aj/1128/WHBC/Obj/A

I am writing on behalf of the owner of n° 71, Pine Grove, Brookmans Park, Hatfield AL9 7BL to raise formal objections to the retrospective planning application (*planning ref: 6/2020/2857/FULL*)

The retrospective planning application is seeking to obtain planning permission for a variation to the original planning consent (*Planning ref: 6/2018/0215 FULL*) which permitted the erection of a pair of part single, part two storey semi-detached dwelling houses with landscaping/off street parking. The variations have been triggered by inaccurate survey drawings which resulted with the rear elevation extending further than envisaged beyond the rear elevations of immediate adjoining properties known as 71 and 75 Pine Grove. The partially implemented development is on hold pending the outcome of retrospective consent application.

Drawing Number 73PG-07	Revision F
----------------------------------	----------------------

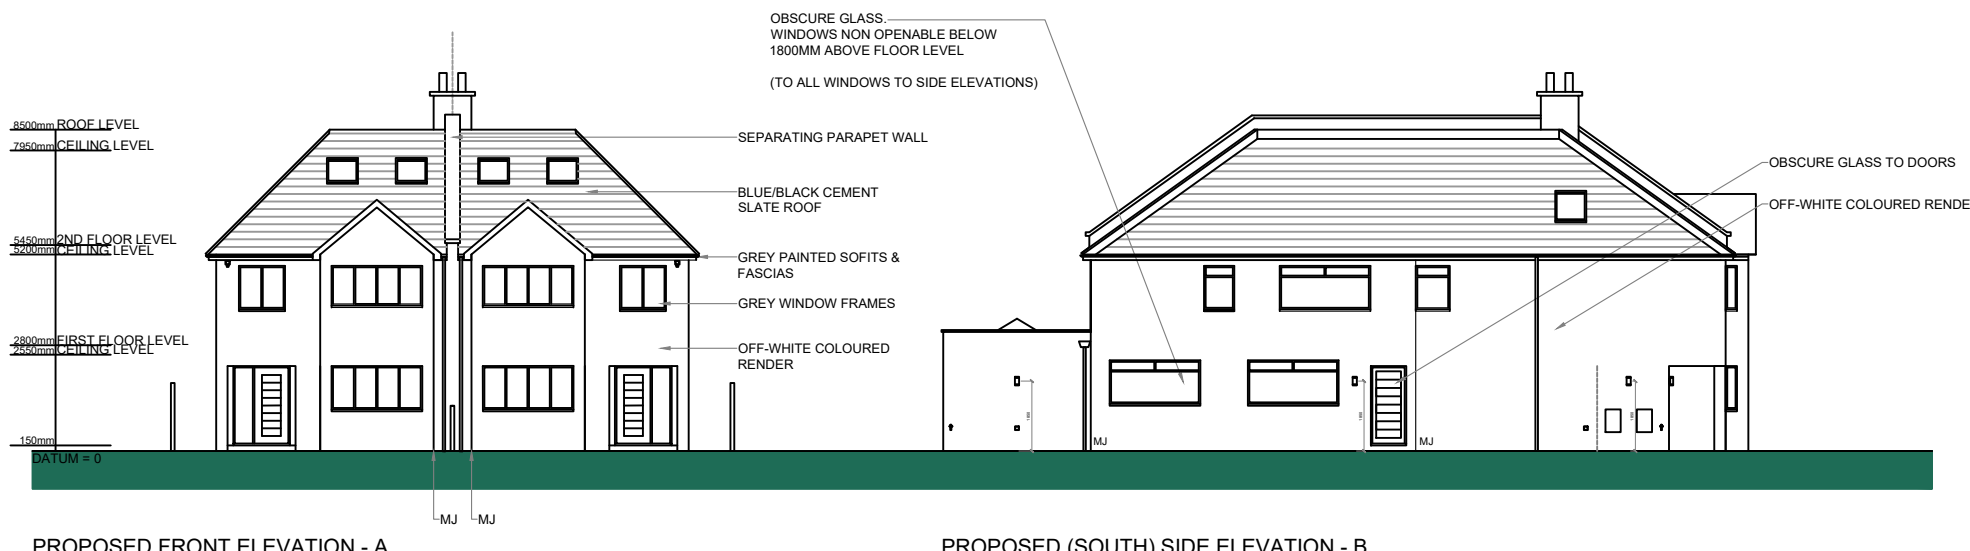
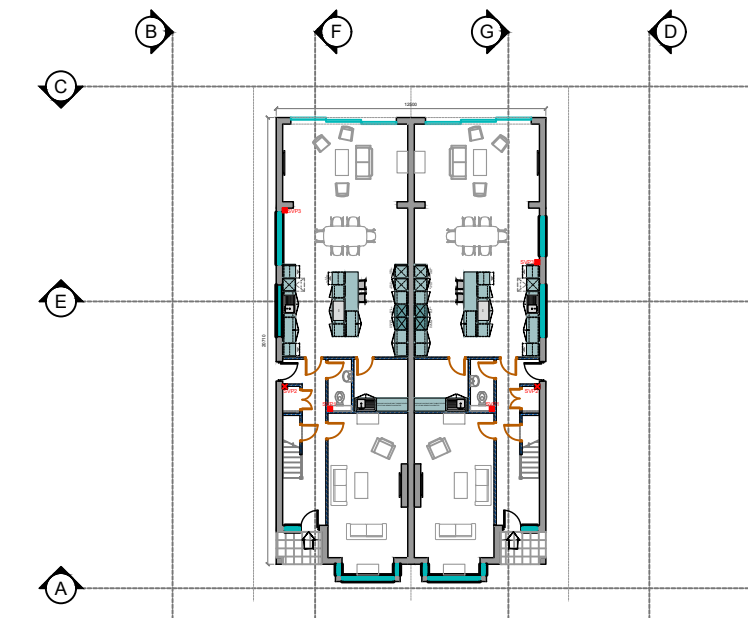
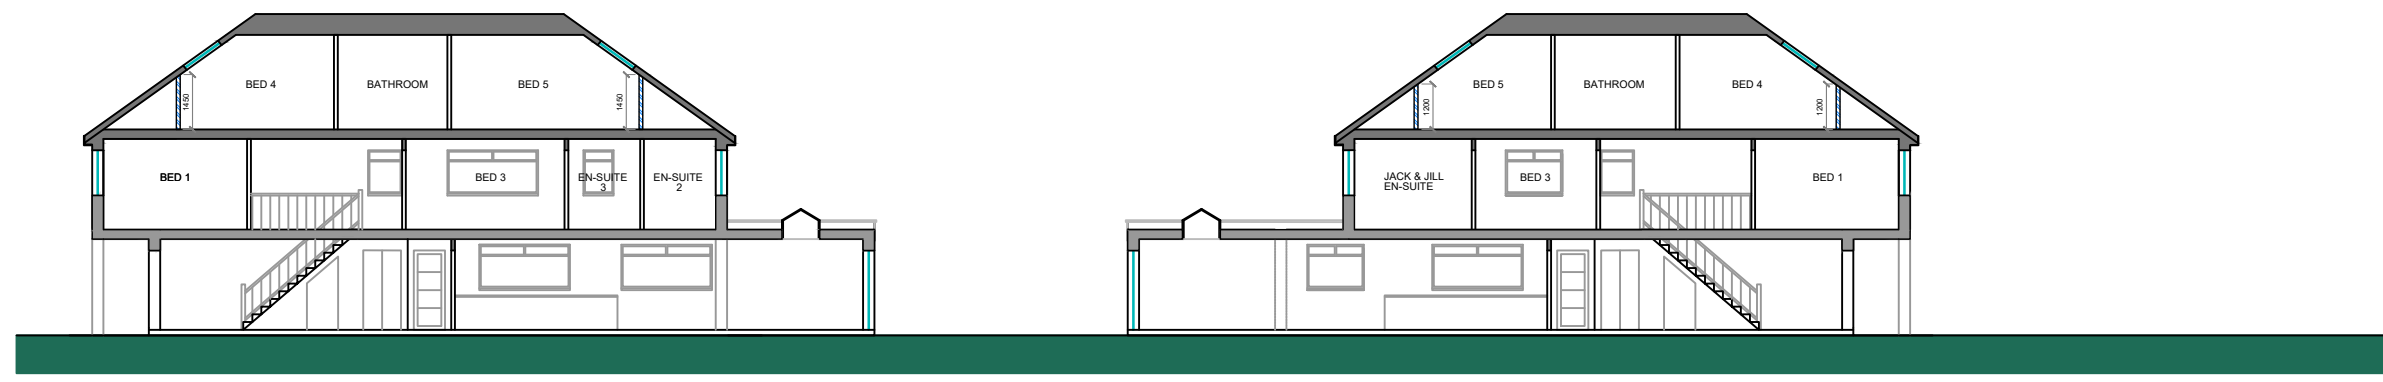
The suggestion that a 3.1m high single storey rear extension within 1.0m of the 1.8m high site boundary fence will not have any visual impact should be challenged.

The size, number and grouping of windows in the flank elevation (*which is within 1.0m from the boundary*) is a concern as there is no reference made to the requirement under Building Regulations to respect “spread of Flame and Heat”. The use of obscure glass and the restriction of openings to be no lower than 1.7m above internal finished floor levels is acknowledged as a reasonable planning condition. However, this does not address spread of flame and heat in the event of a fire and this will inevitably give rise to variations to the window design as the minimum unprotected areas has been significantly exceeded and compromised. Whilst it is appreciated this is a “Building Regulation” as opposed to a “Planning” issue, it is considered this matter should be raised with Building Control as it can materially affect the flank elevation design and ventilation of habitable rooms in particular the first-floor bedroom which is a planning matter.

Drawing Number 73PG-11	Revision J
---------------------------	---------------

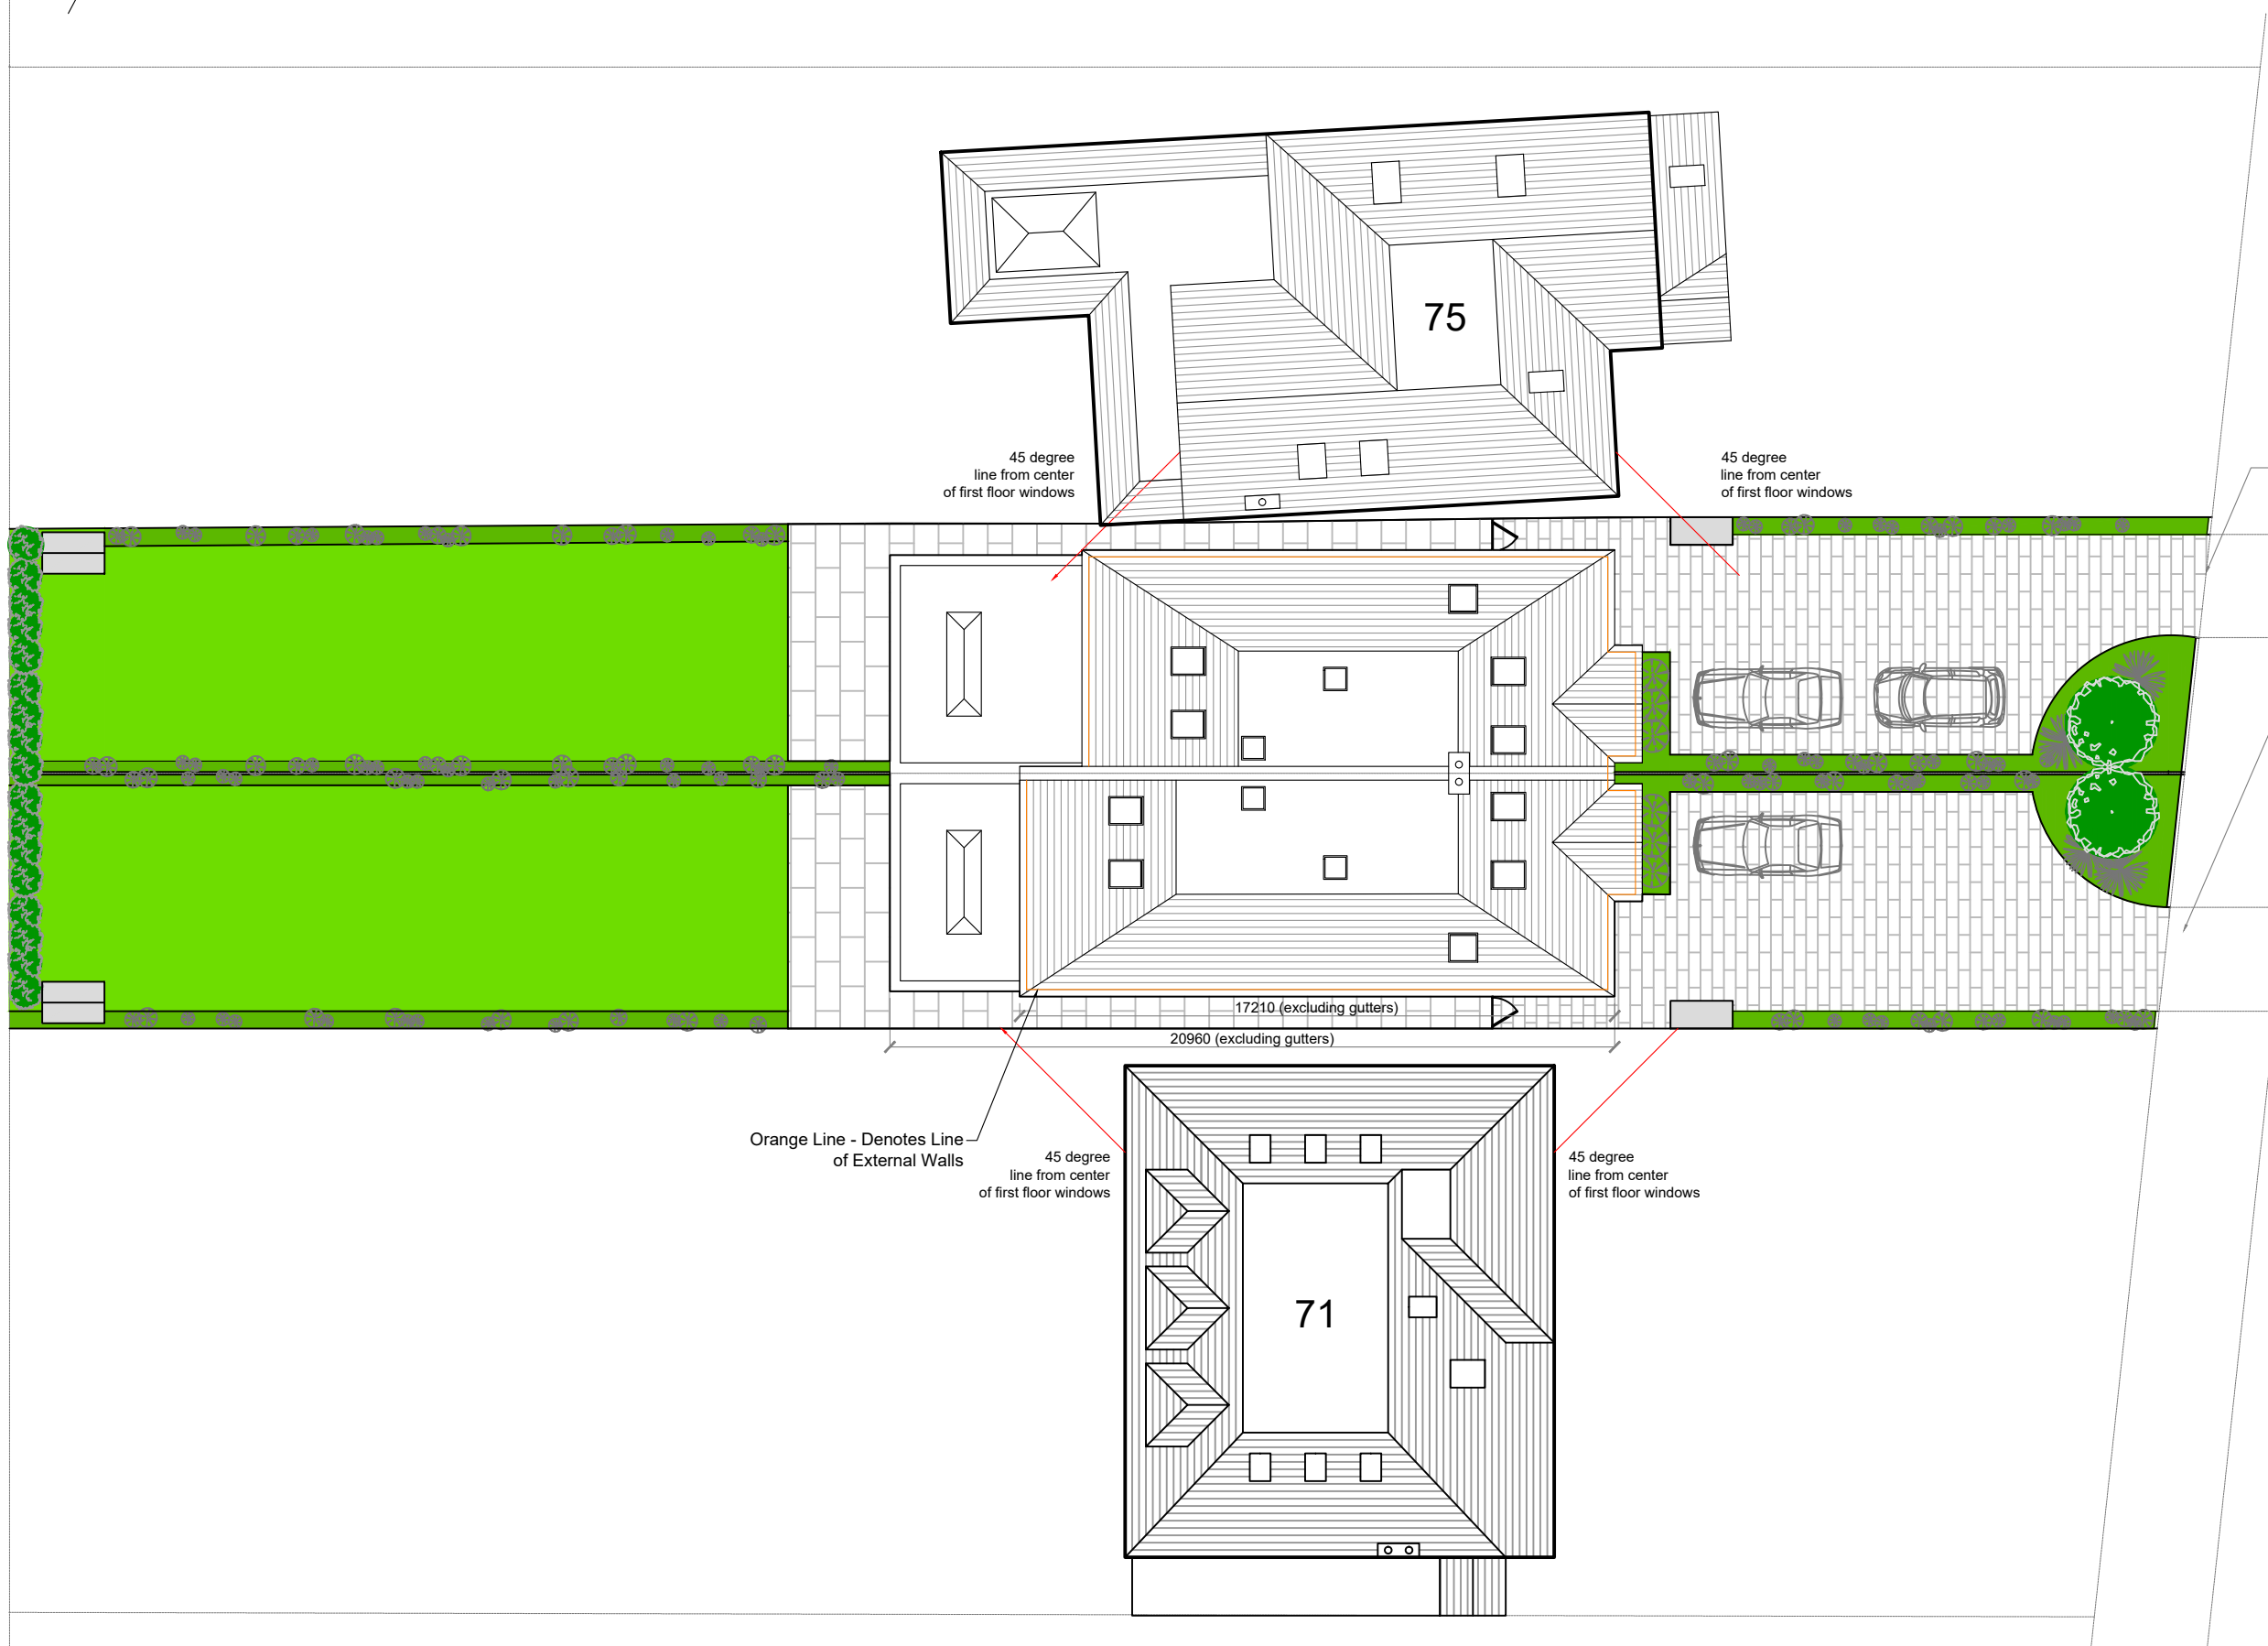
It would appear the relationship of the proposed development at n° 73 Pine Grove with n° 71 remains suspect. Indeed the rear projections are increased by 1.75m when compared with the approved scheme and 870mm shorter than the “as built” reality in the retrospective scheme. (Refer to Fig 1 and 2). The number of revisions to the site plan between the approved revision “B” to current revision “J” speaks volumes.

The following marked up plan (fig 2) illustrates the fact the rear single storey addition at n° 71 Pine Grove will impinge upon the 45 degree “line of sight” taken from the centre of the established rear ground storey elevation glazed doors at n° 71 Pine Grove by 2.2m . This is significant and will therefore be undoubtedly harmful. This projection also part represents the current unauthorised and controversial rear projection beyond that approved of approximately 1.75m when compared with the approved “Proposed Site Plan” (ref 73PG-11 rev “B”). As such this increased rear projection at single storey level (*at the very least 1.75m*) is considered to be in breach of planning guidance that is aimed at avoiding as in this case “overly dominant projections” consequent to their length and height.

Fig 2. Marked up extract planning application plan 73PG-11 rev “J”

The ground storey rear projection should beat the very least set back by 1.75m from the proposed rear elevation or preferably be rebated and part set away from the flank boundary line to respect the 45 degree "line of sight from" n° 71 Pine Grove.
